Application by Rosefield Energyfarm Limited for an order granting development consent for the Rosefield Solar Farm

The Examining Authority's (ExA) schedule of proposed changes to the applicant's draft Development Consent Order (dDCO) (Revision 07) [REP4-006]

Issued on: 15 July 2026

DOCUMENT:
APPLICATION DRAWINGS FOR APPROVAL
REGULATION 5(2)(k)
DRAWING TITLE:
STREETS, RIGHTS OF WAY AND ACCESS PLANS
SHEET 1 OF 8

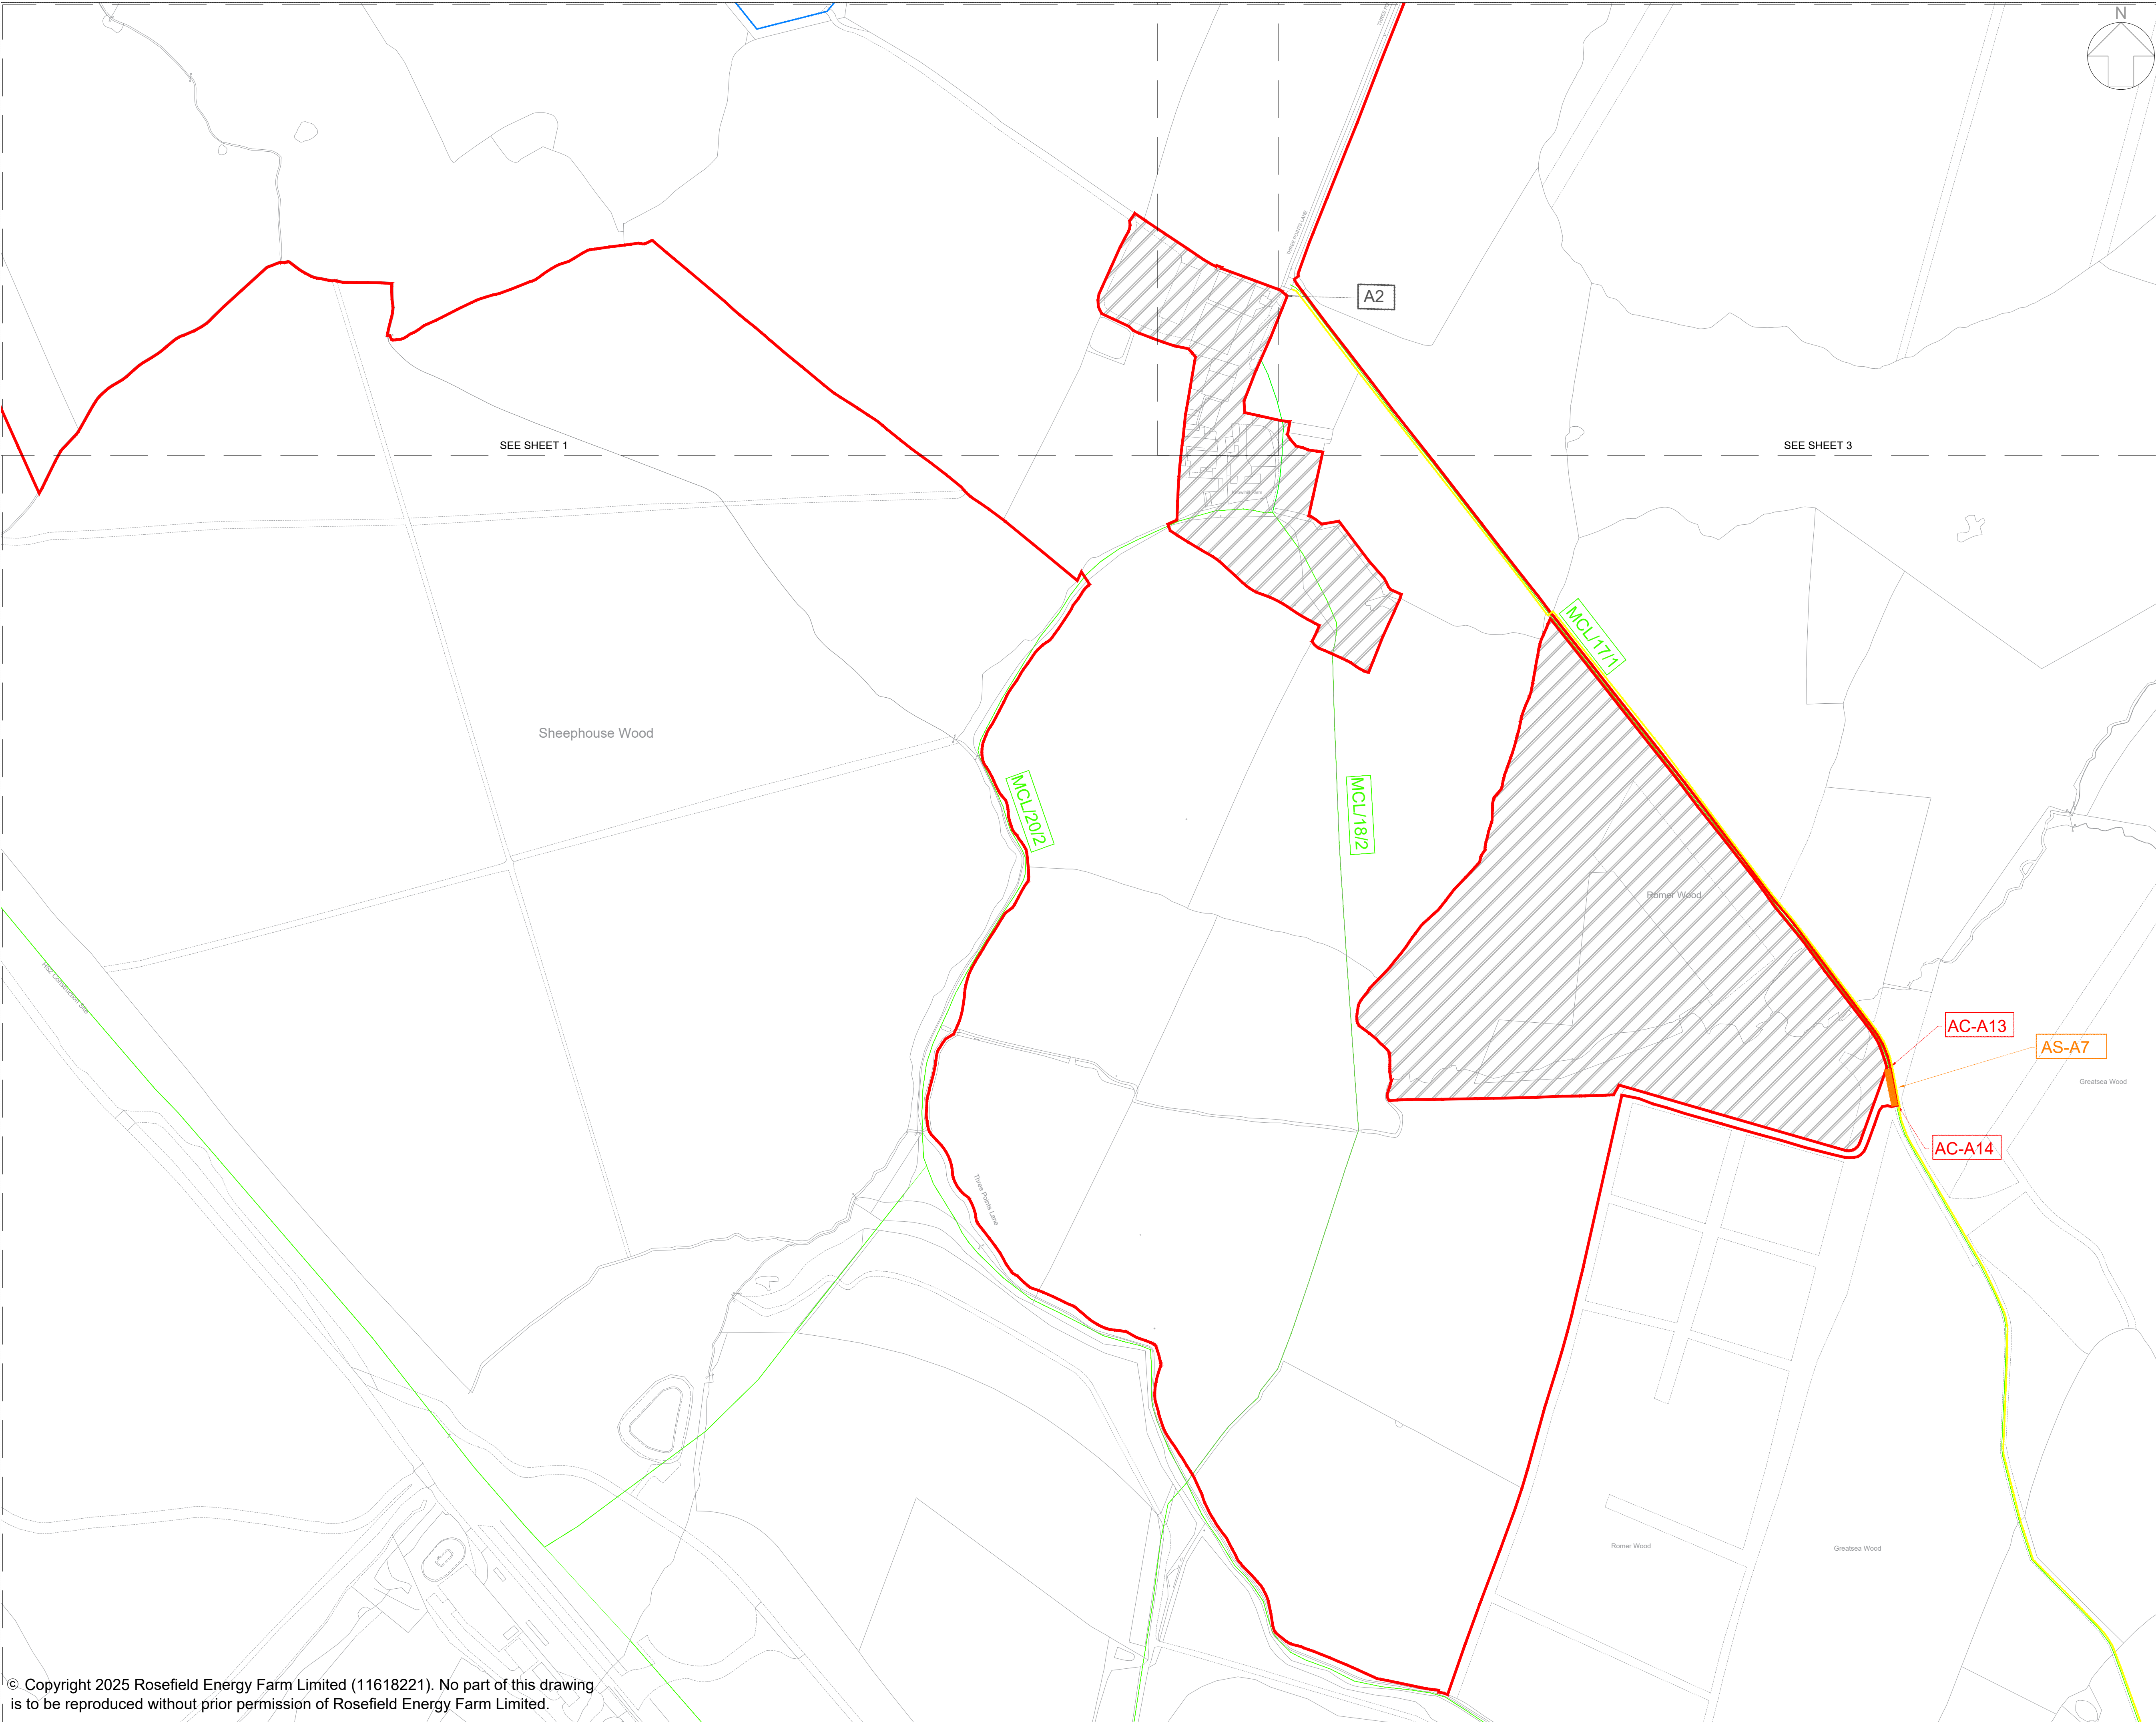
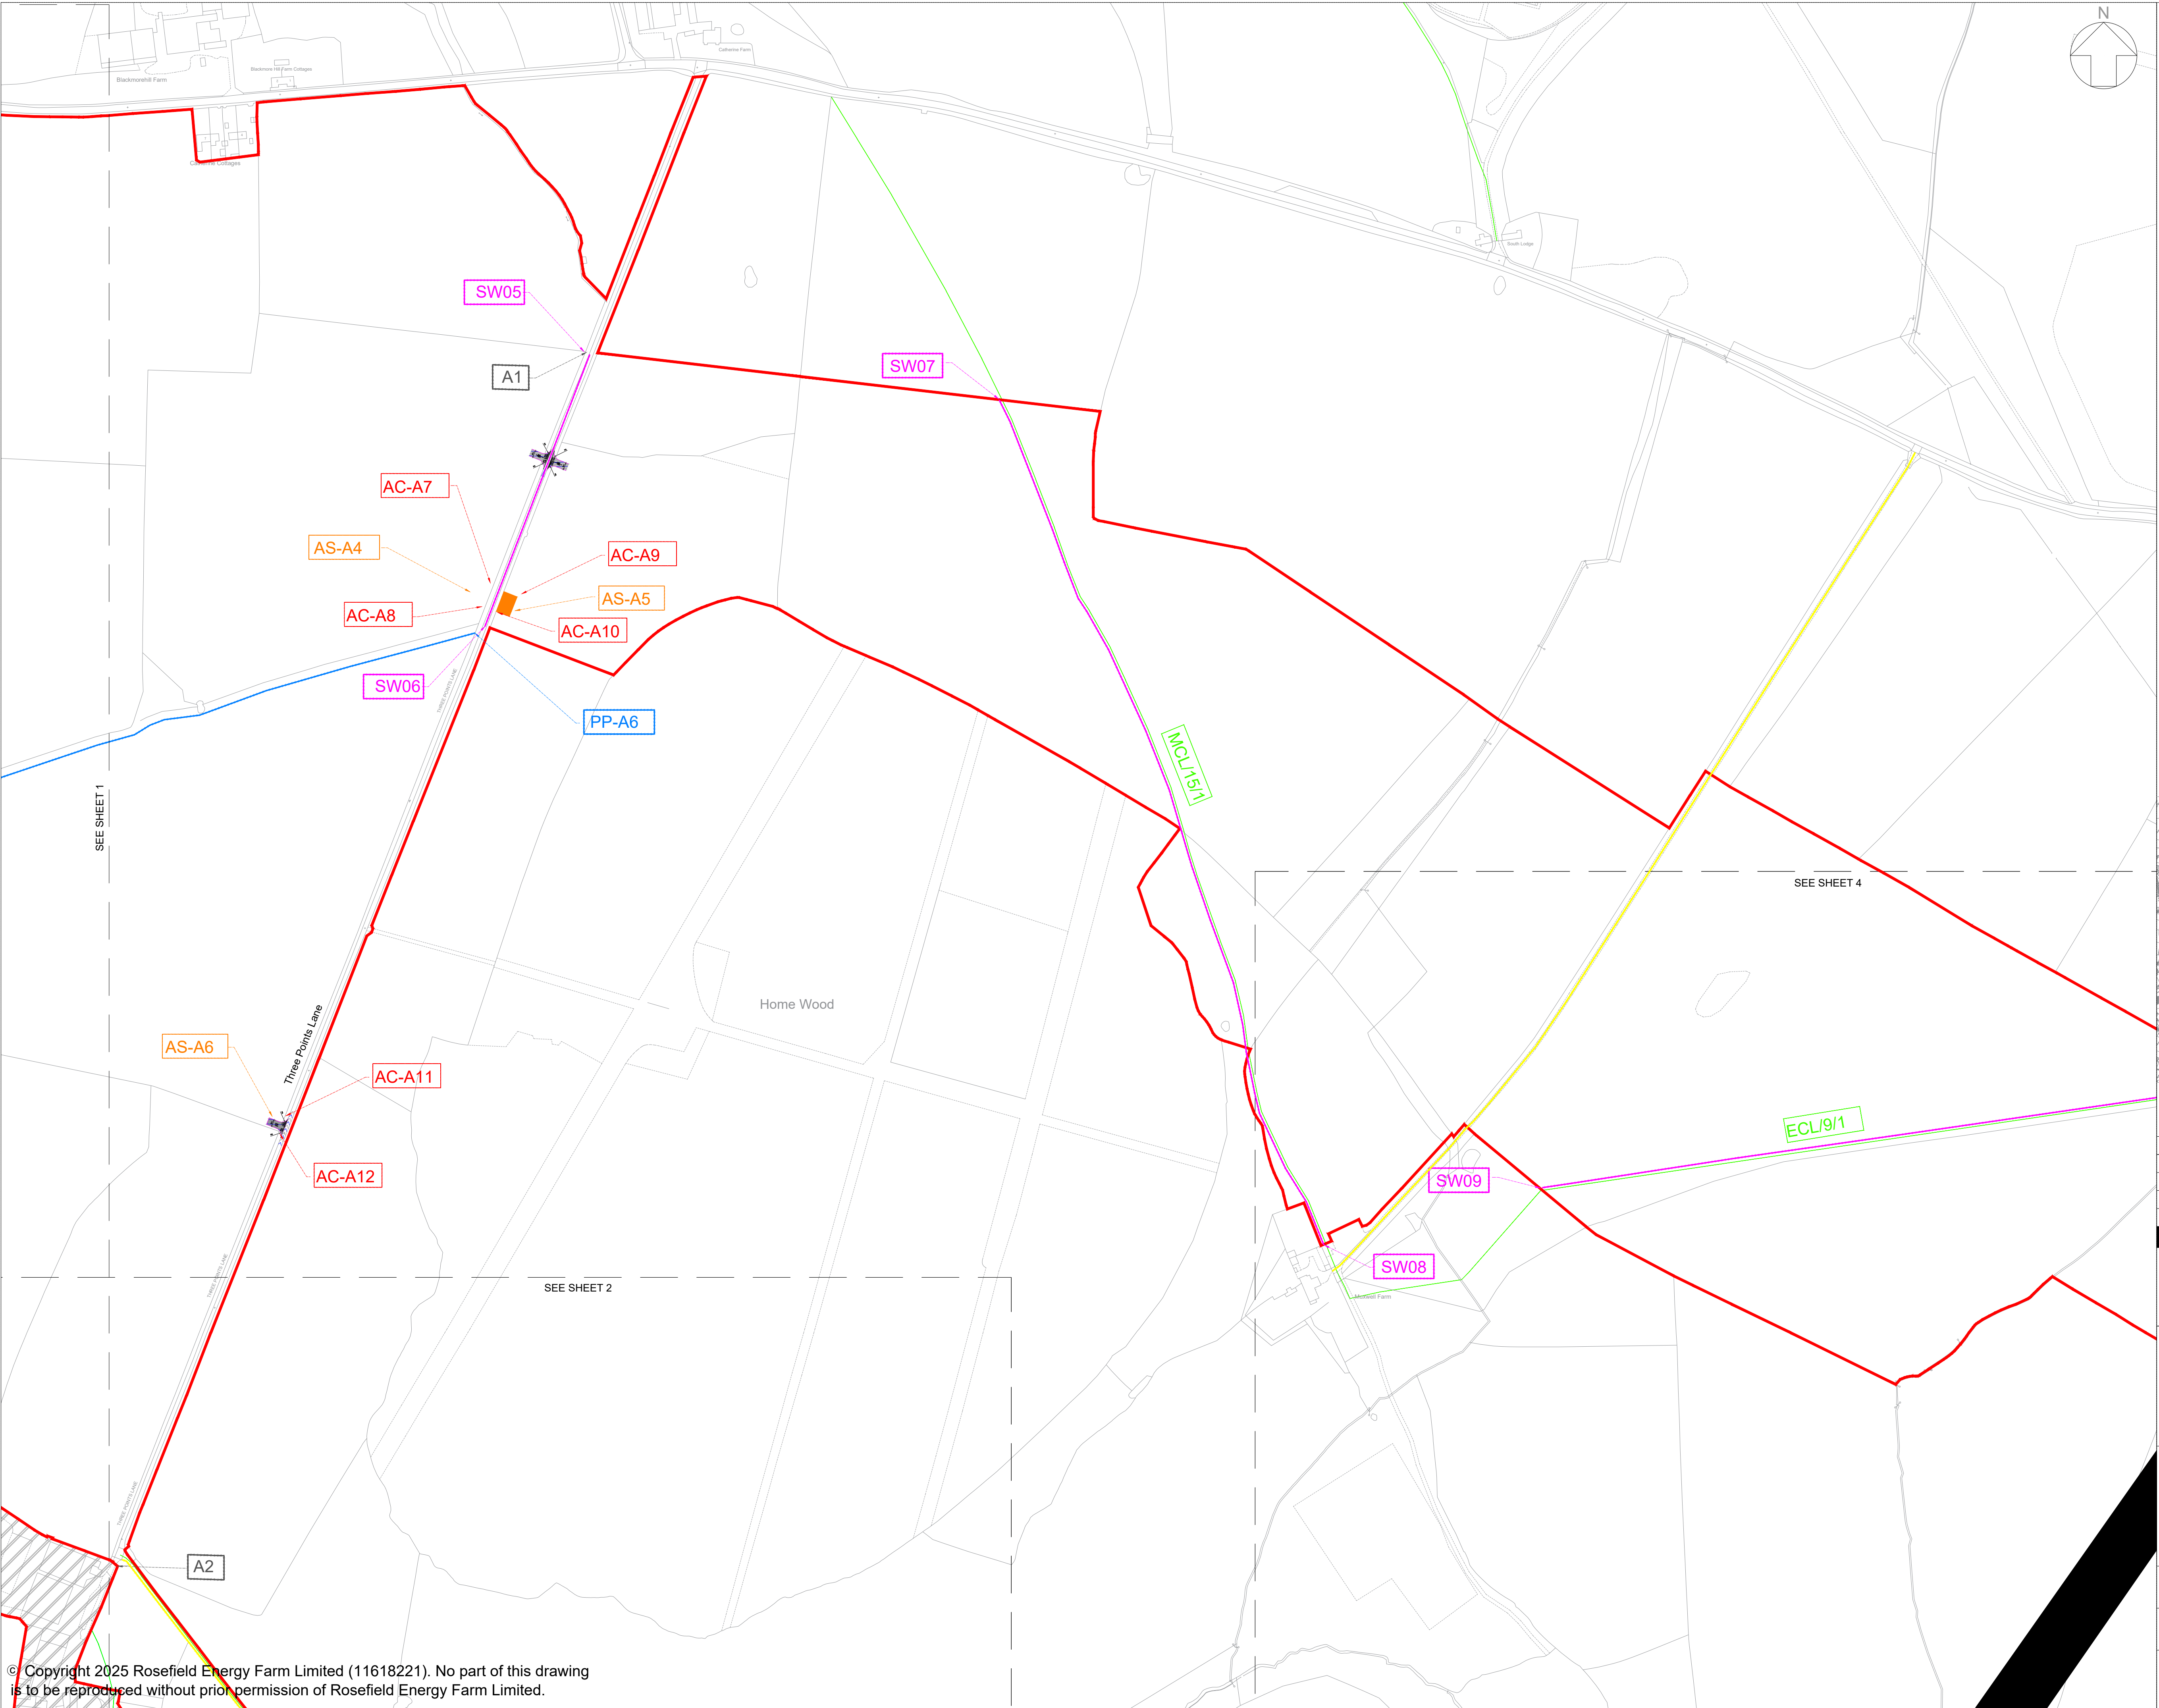
Article/ Schedule	ExA's proposed changes Deletions shown as strike through (for example) Insertions shown in bold (for example)	ExA's reasoning and comments
		However, the ExA considers this should be expressly stated in the dDCO.
Article 12 – Temporary prohibition or restriction on the use of streets and public rights of way	(10) The undertaker must restore any public right of way that has been temporarily altered under this Order to the reasonable satisfaction of the street authority	This provision would be the equivalent to the obligation contained at Article 10(2) and the ExA considers it is required to ensure a proper reinstatement of public rights of way.
Article 14 – Use of private roads	(1) The undertaker may use any the private roads specified in (2) For the purposes of section 9 (requirement of licence for felling) of the Forestry Act 1967(b) any felling comprised in the carrying out of any work or operation required for the purposes of, or in connection with, the construction of the authorised development is deemed to be immediately required for the purpose of carrying out Schedule “X” within the Order limits for the passage of persons or vehicles (with or without materials, plant and machinery) for the purposes of, or in connection with, the construction or maintenance of the authorised development.	The ExA considers that this proposed power is too broad and for clarity needs to be restricted to those private streets that the applicant intends to use for the proposed development. The update to the Streets, Rights of Way and Access Plans at deadline 4 [REP4-005] does not provide this clarity, only showing the location of all private streets within the order limits.
